Application No: FG/140/20/HH
Site Address: 10 Highdown Way Ferring BN12 6QQ
Description of works: Loft conversion, side extension and porch to front

Thank you for your internet representation made on 8th December 2020 which has been recorded as an objection with the comments as follows:

Proposed Roof Layout

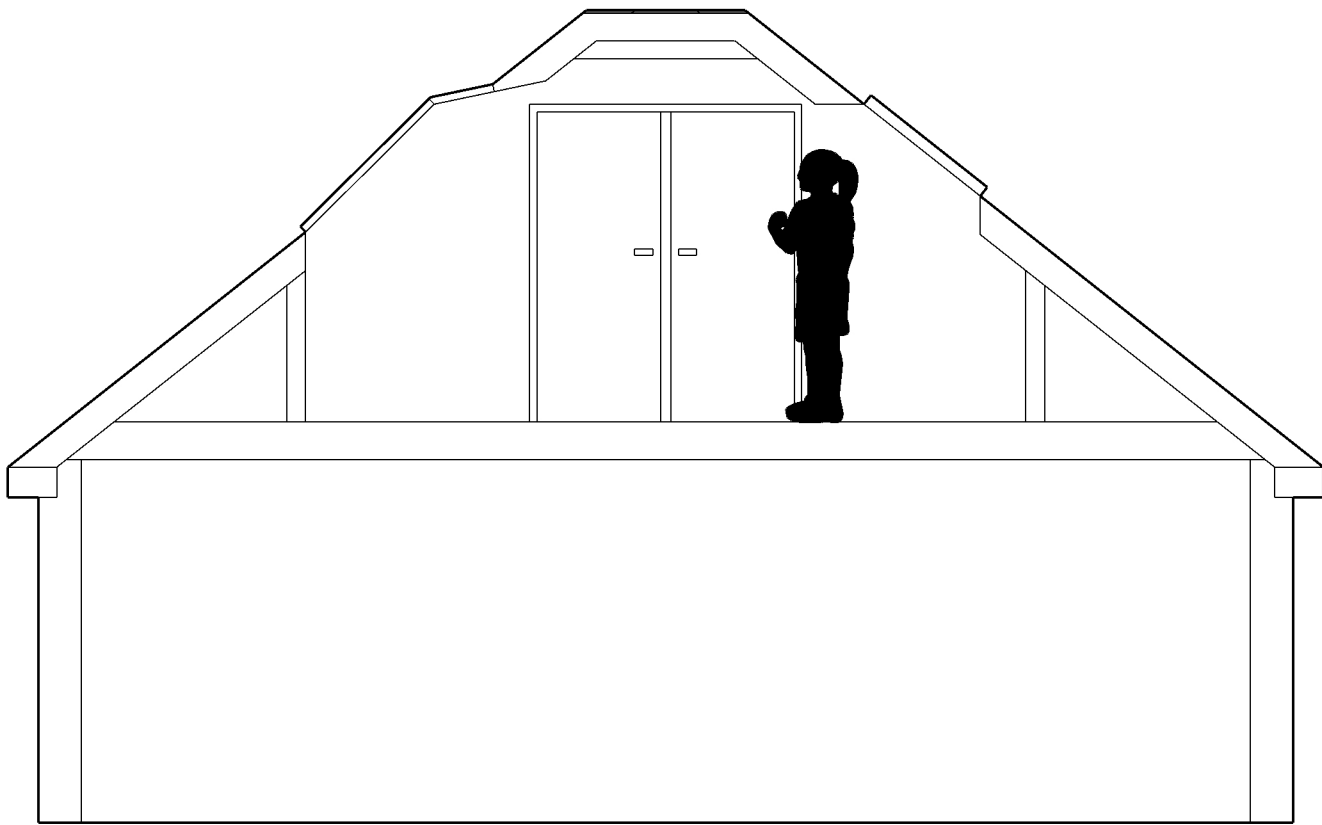
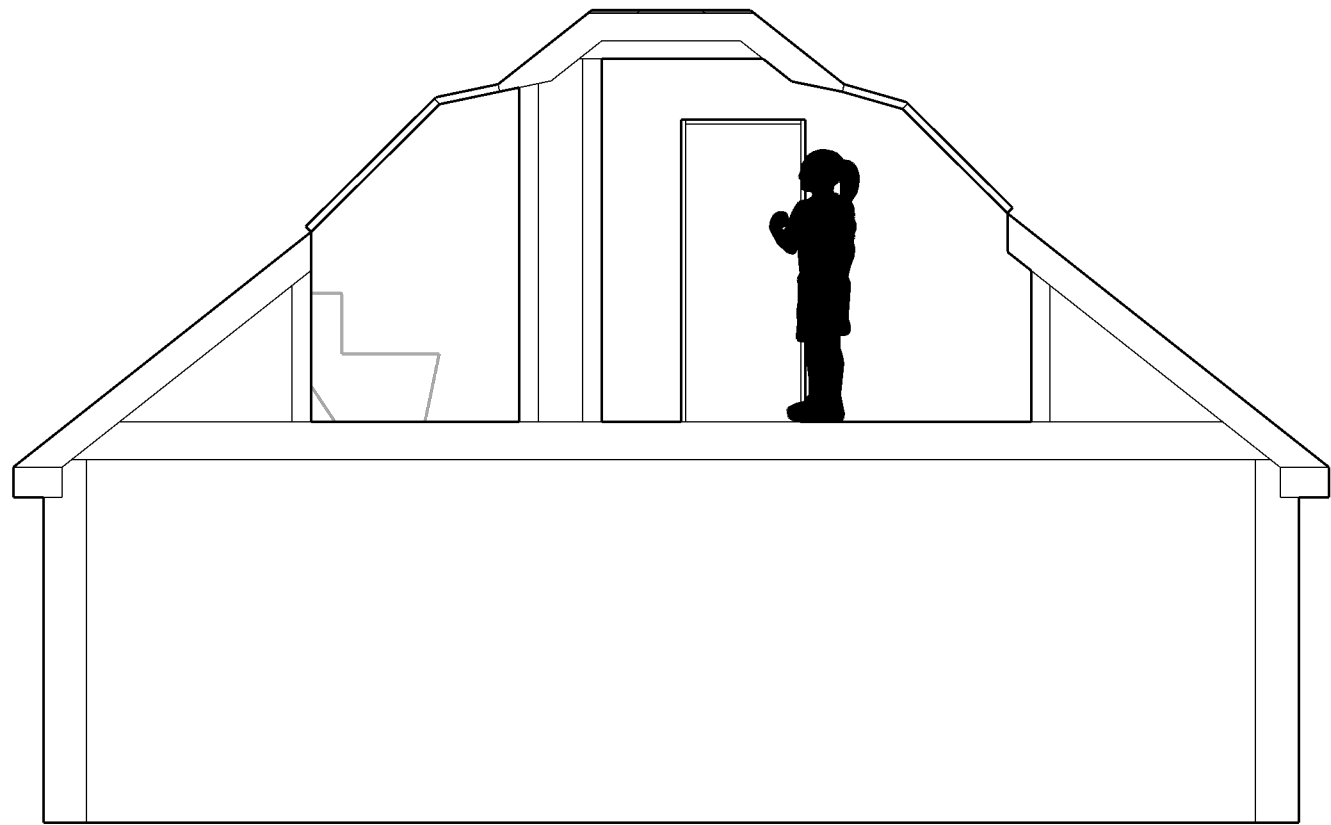
Ferring Parish Council objects to this application on the grounds that the proposed dormers do not appear to meet the conditions applied to the previous application (FG/59/20HH) for fixed and obscured glass. The scale of the proposed dormers increases overlooking of neighbouring properties and make these conditions even more necessary than the previously approved design.
